**WELWYN HATFIELD BOROUGH COUNCIL
ASSISTANT DIRECTOR (PLANNING)**

DELEGATED APPLICATION

Application No: 6/2023/2321/FULL
Location: Cuffley Gate Sopers Road Cuffley Potters Bar EN6 4RY
Proposal: Erection of a new steel structure canopy (sheltering) for ventilation and storing goods for the manufacturing process and extension to existing sheltering by the west block for ventilation and storing goods for the manufacturing process
Officer: Ms Elizabeth Mugova

Recommendation: Granted

TITLE:
PROPOSED ELEVATIONS

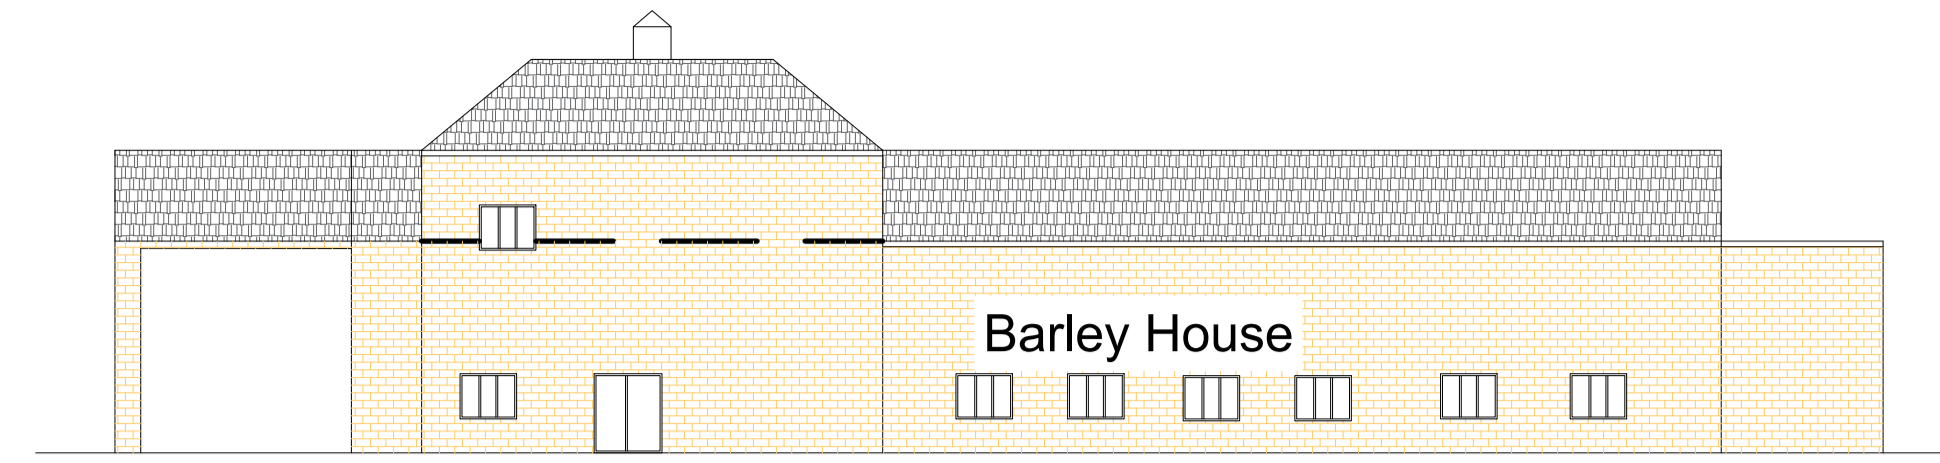
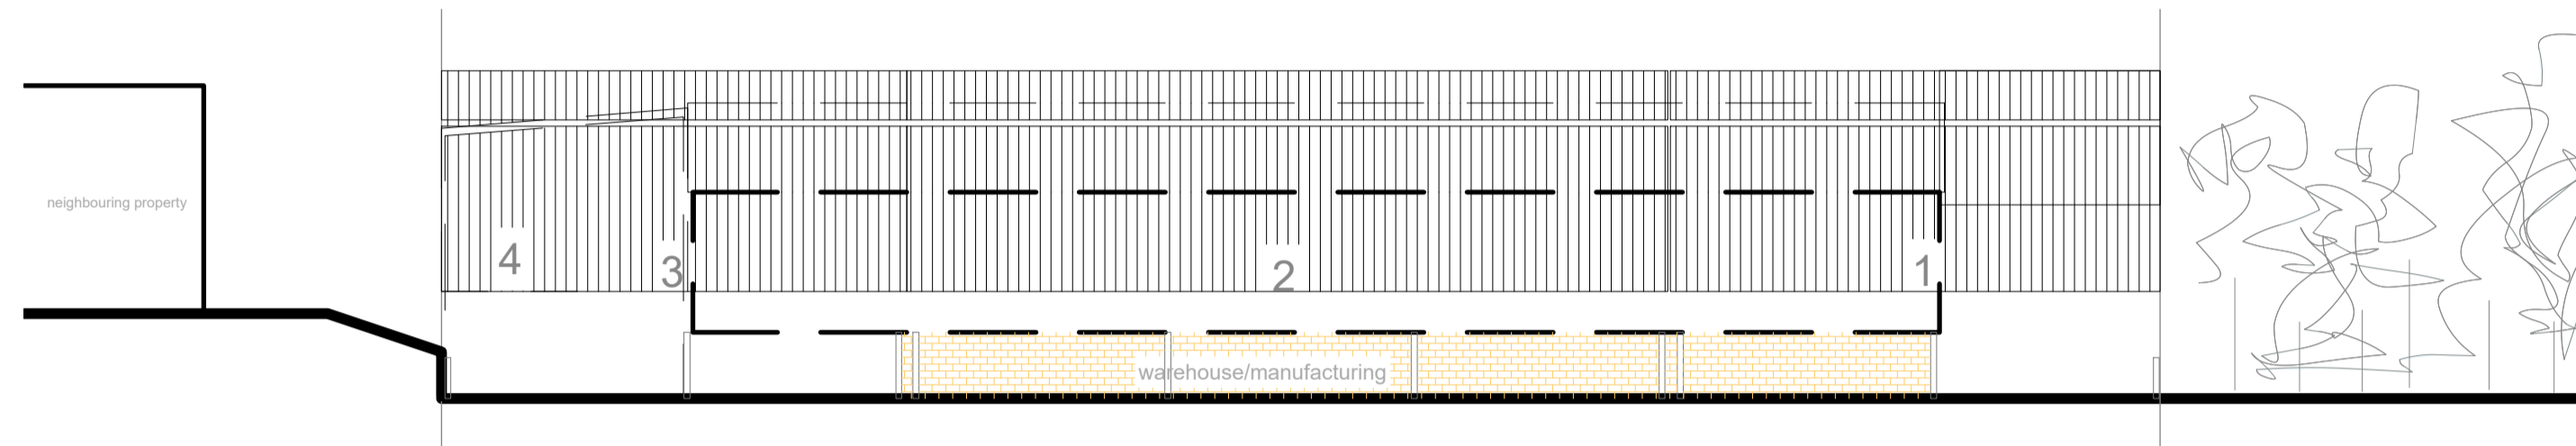
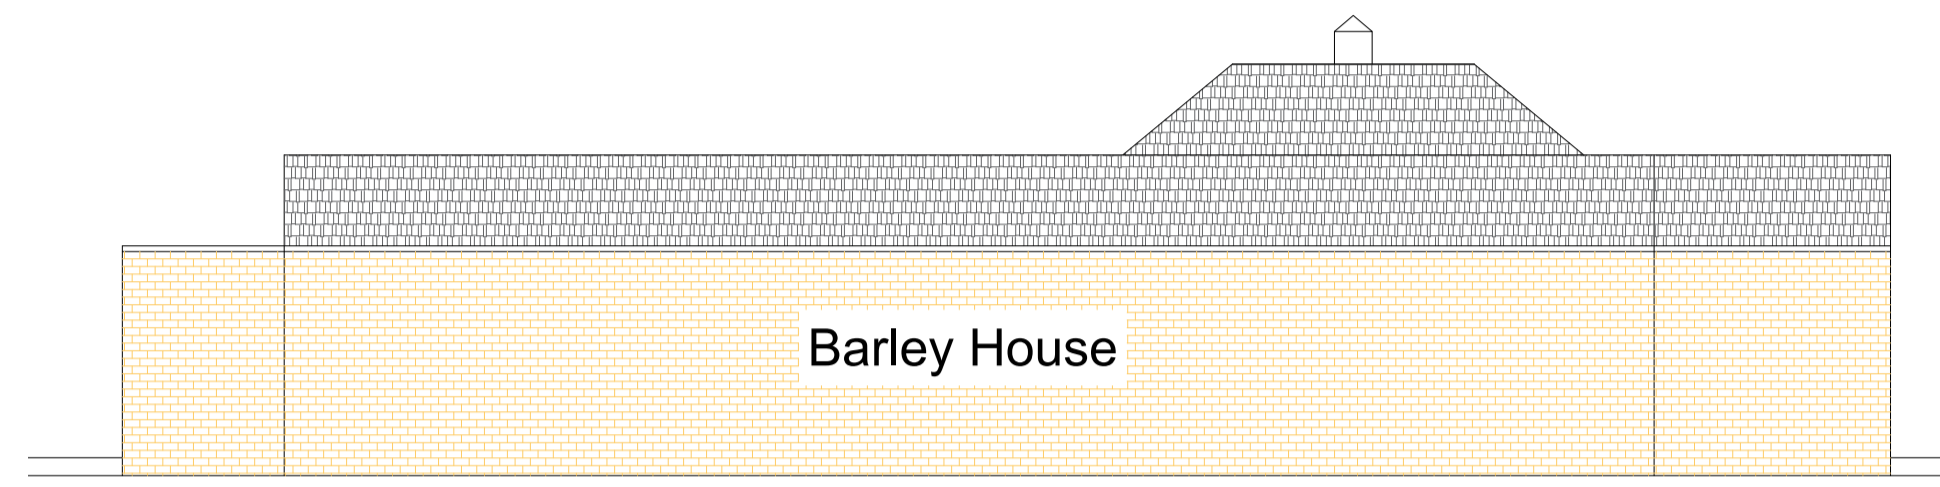
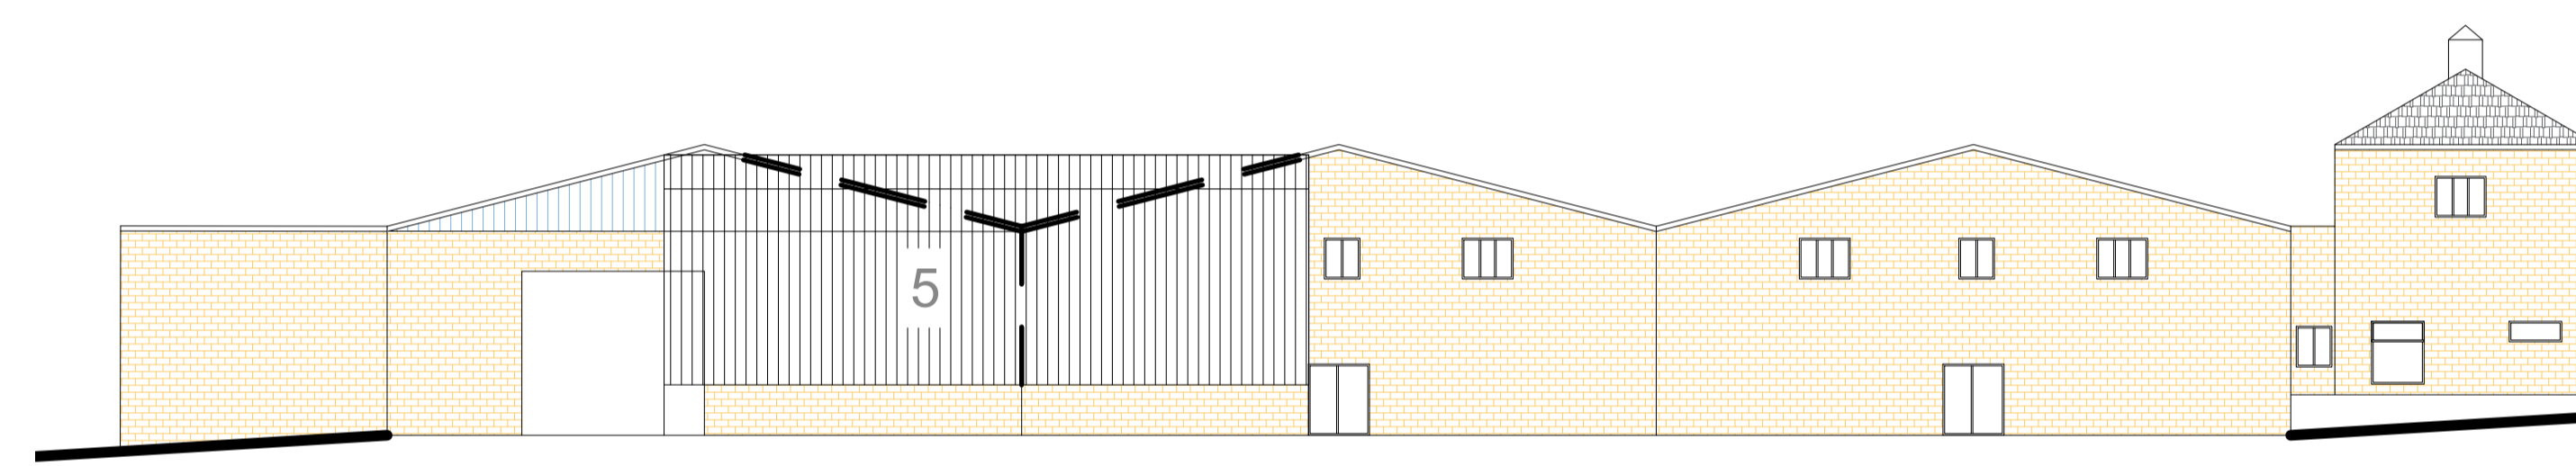
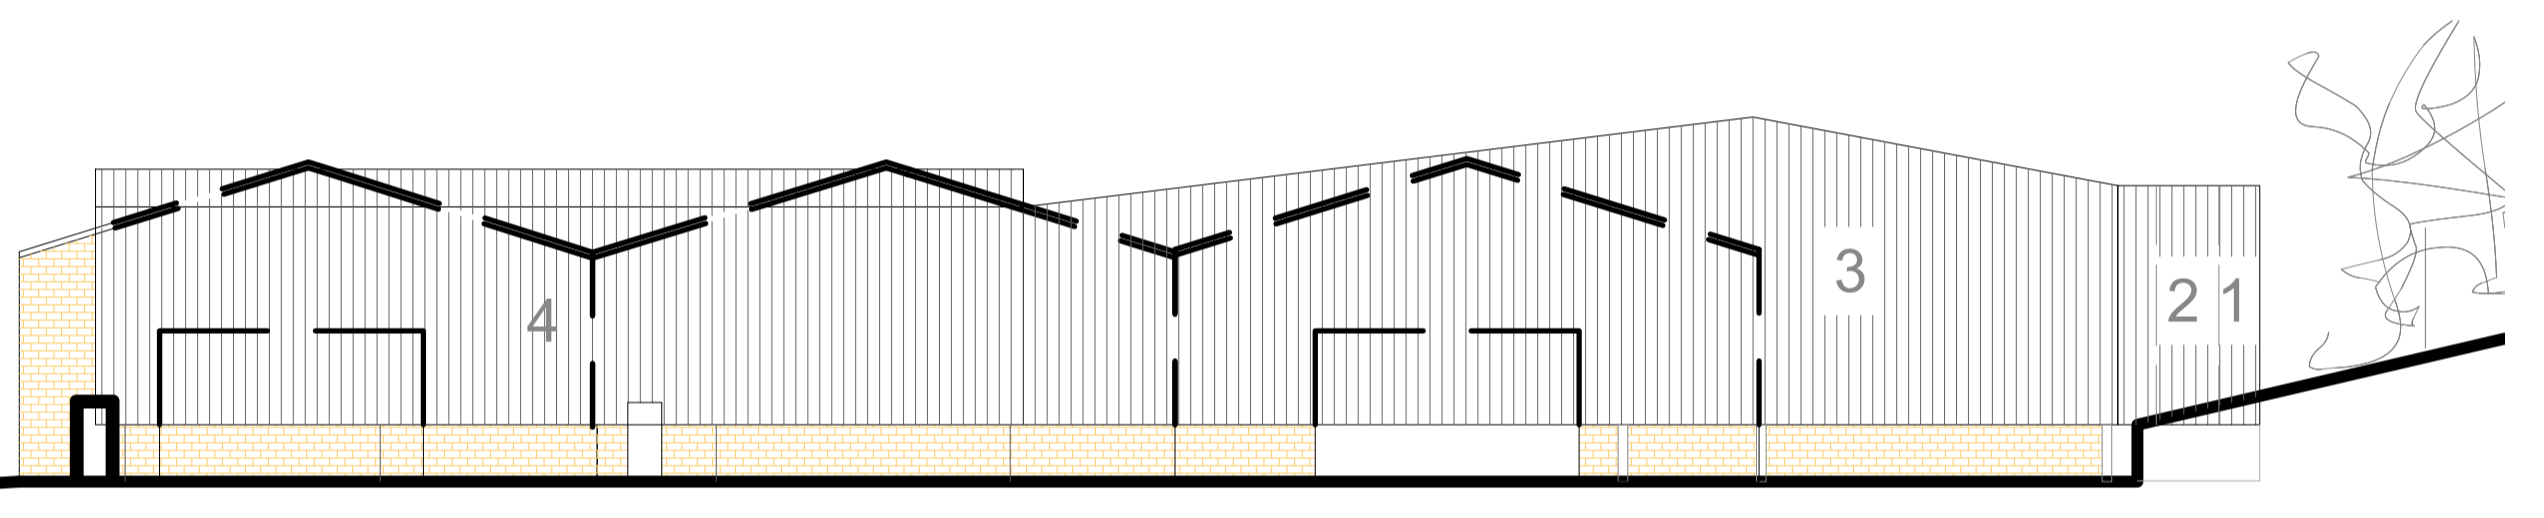
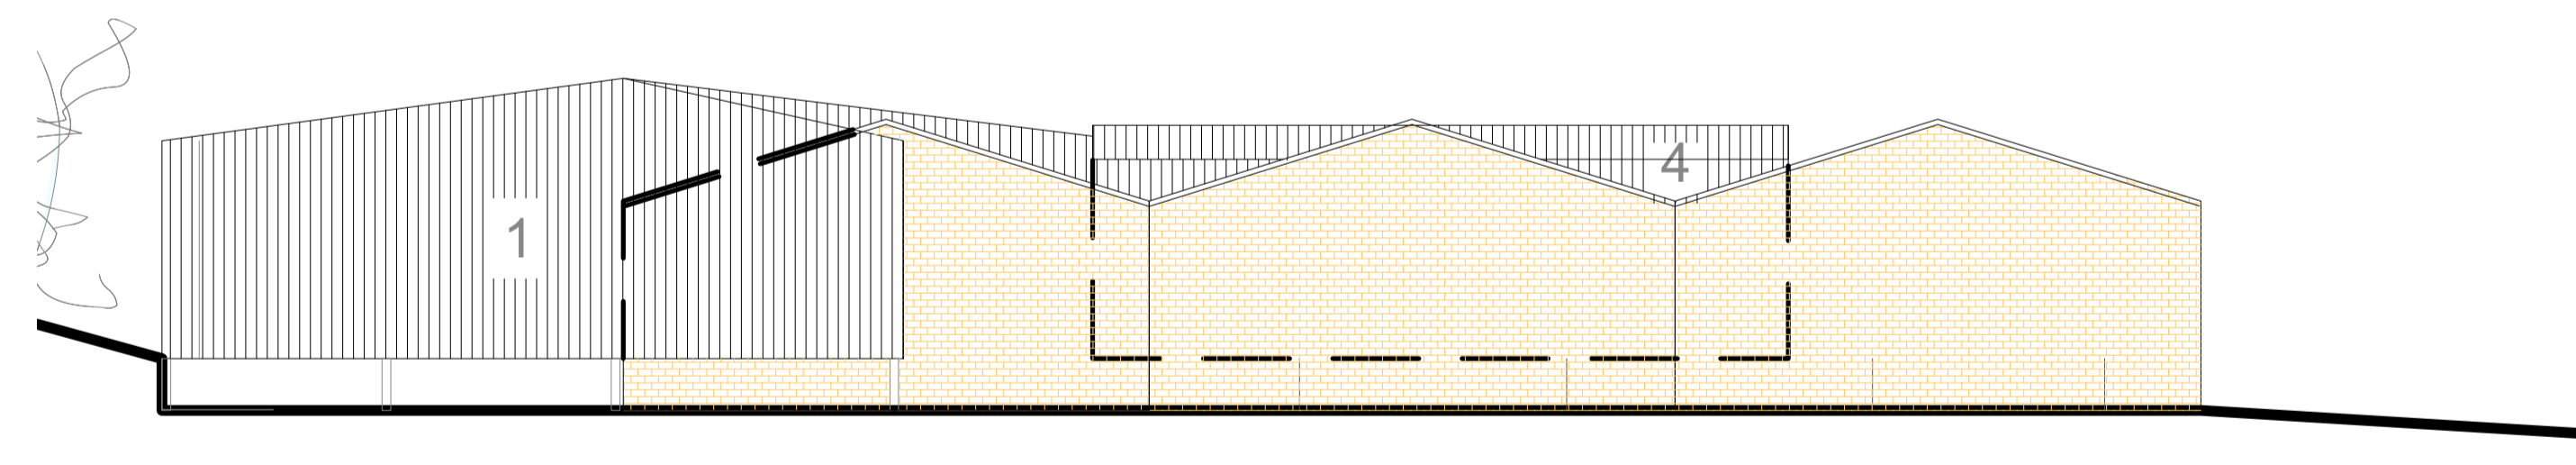
<p>The proposal includes an extension to the existing sheltering next to the MIR PAC building for ventilation and storing goods for the manufacturing process. This element of the proposal would be sited along the boundary with Media House where there are windows serving offices on the ground and first floor. The height of the structure would be retained and there would be a gap of approximately 5 metres between the boundary wall and flank wall of the neighbouring building. With regards to the structure canopy next to Barley House, it would be located adjacent to containers sited at the recycling centre next door. It is considered that the height, scale and siting of both structures would not appear dominant and prominent within the surrounding industrial estate.</p> <p>The structures would be finished in metal cladding sheets. External materials can be secured via a condition. It is considered that the design of the structures is acceptable in this location.</p> <p>Overall, the proposed development would not adversely affect the character and appearance of the existing buildings and surrounding area. Accordingly, this proposal accords with local and national policies.</p>

<p>Impact on neighbours</p>	<p>Policy SADM11 of the Local Plan seeks to provide a good standard of amenity for buildings and external open space in line with the Council's Supplementary Design Guidance. The Council's SDG states that new development should not cause loss of light or be unduly dominant from adjoining/adjacent properties.</p> <p>The comments from the adjoining neighbour are acknowledged.</p> <p>The extension to the structure next to the MIR PAC building will most likely impact the ground and first floor offices at Media House. The side elevation of this neighbouring building is south facing and it experiences light from morning till early afternoon. Whilst the existing structure blocks light to the ground floor rear offices, the extension would not result in a significant change to the current situation. Additionally, given the scale and separation distance, this would limit the impact on Media House.</p> <p>The proposed structure next to Barley House would be close to containers and area of hardstanding at the neighbouring recycling centre. As such, it is not considered that this structure would impact on the neighbouring occupiers.</p> <p>Overall, it is considered that the proposal would not have an unduly adverse impact on the occupiers of neighbouring buildings.</p>
